JN 22007

Subject: **Review of Revised Plans**
Proposed New Residence
6950 Southeast Maker Street
Mercer Island, Washington

We have been provided with the revised plans, which include the architectural plans (Jeffrey Almeter; June 2, 2023), shoring plans (Jeffrey Almeter and Buker Engineering; June 2, 2023), civil plans (Goldsmith Land Development Services; June 2, 2023), and the structural drawings (DS Engineering; February 2, 2023).

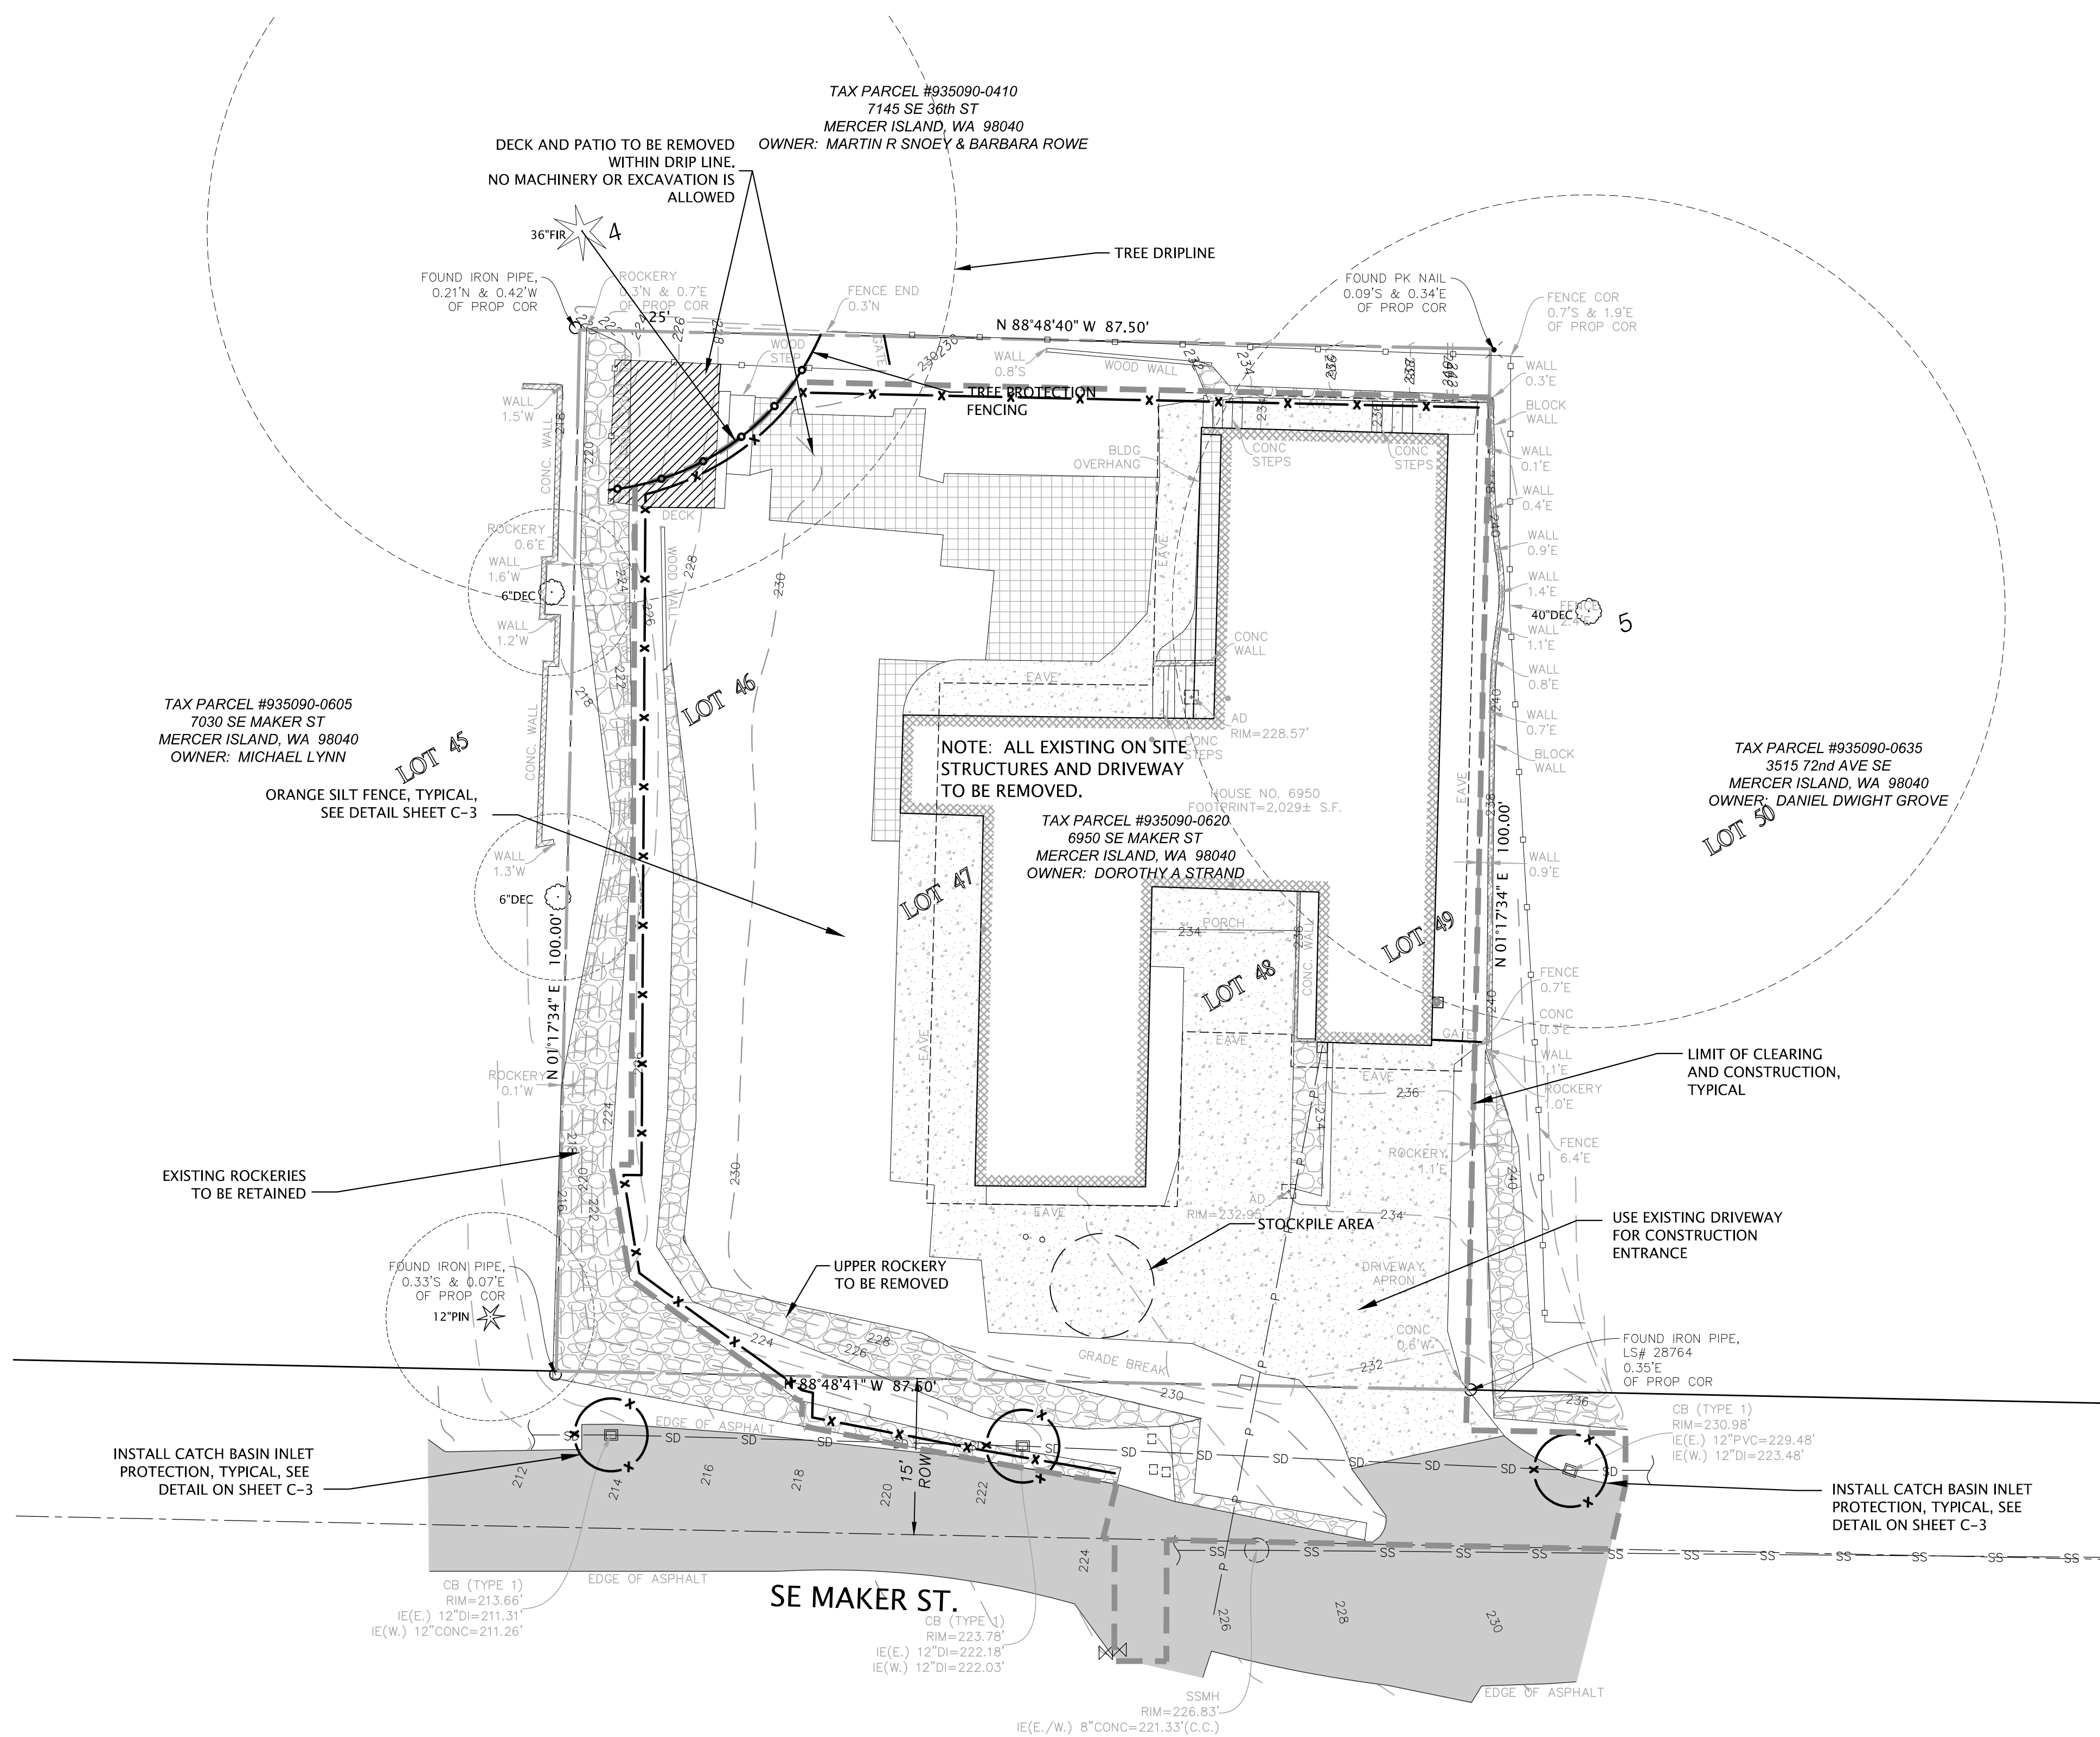
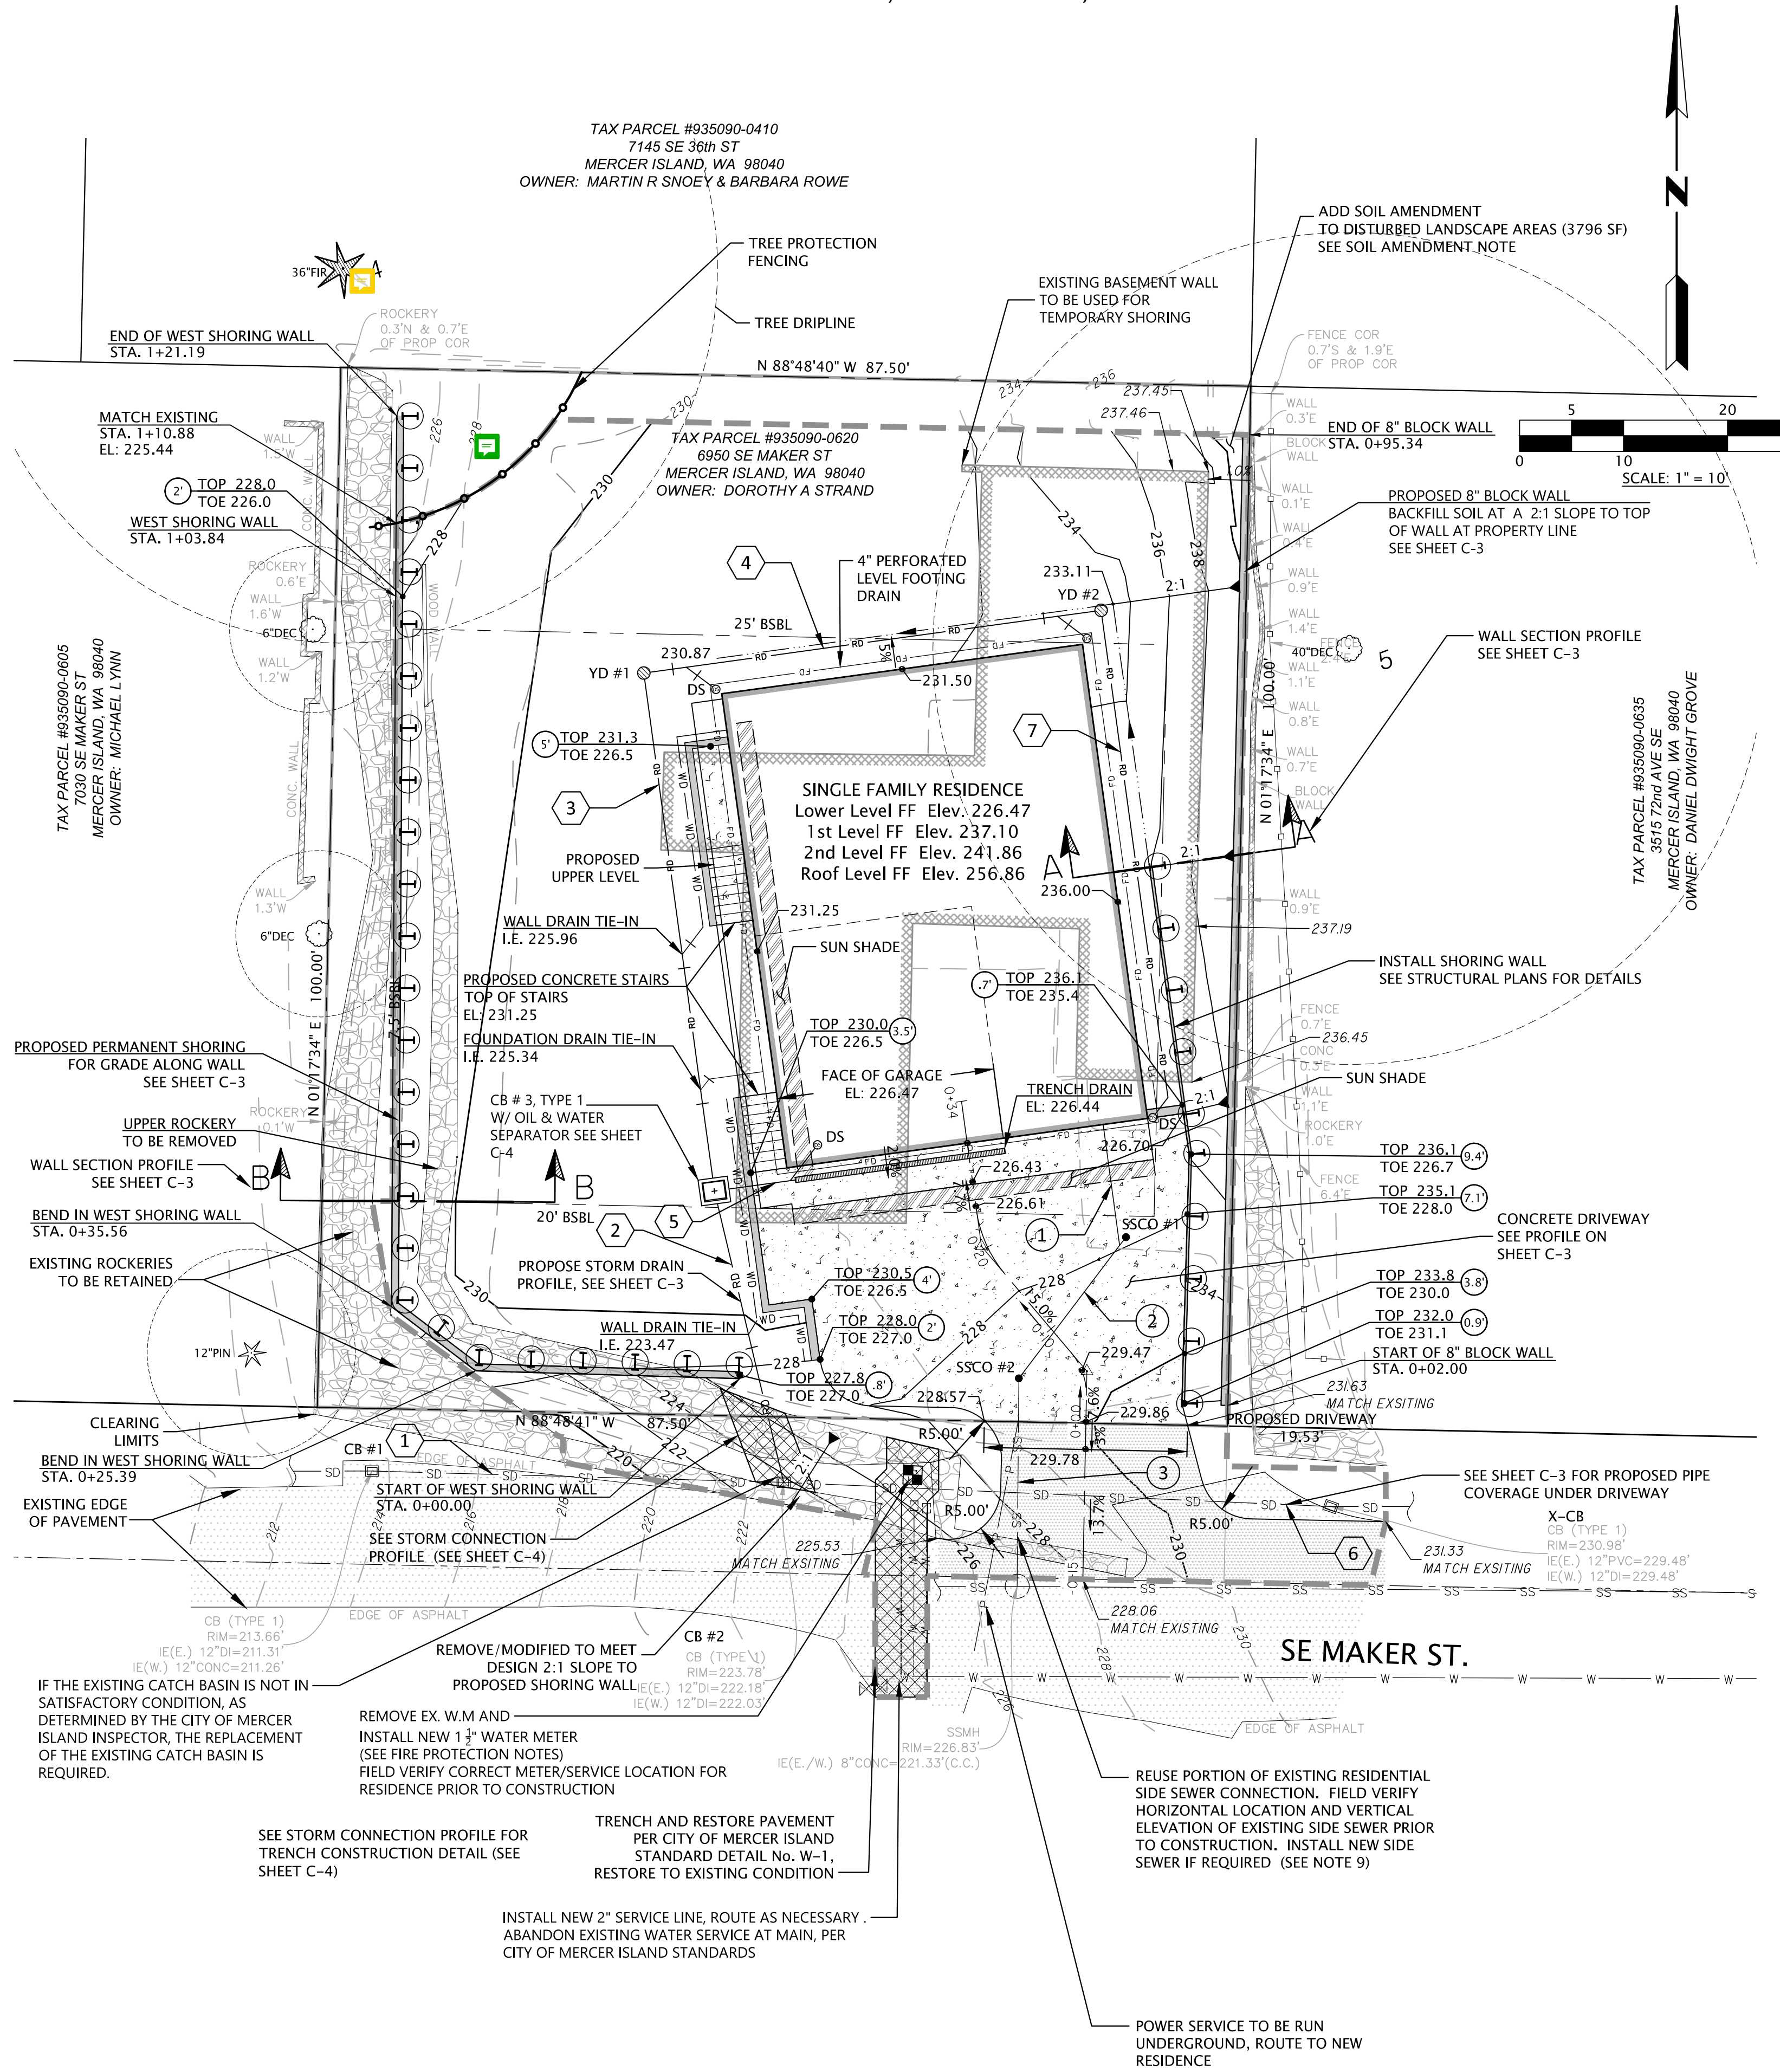
The Site Plan and sections on SH1, as well as sheets C-2 and C-3, properly illustrate the fill berm and modular block wall to be constructed as protection against a potential failure of the eastern neighbor's modular block wall.

Where the new storm outfall pipe will extend to S.E. Maker Street, the existing rockery will be removed, and the ground will be lowered and regraded to a sloping condition between the end of the stabilization wall and the new driveway.
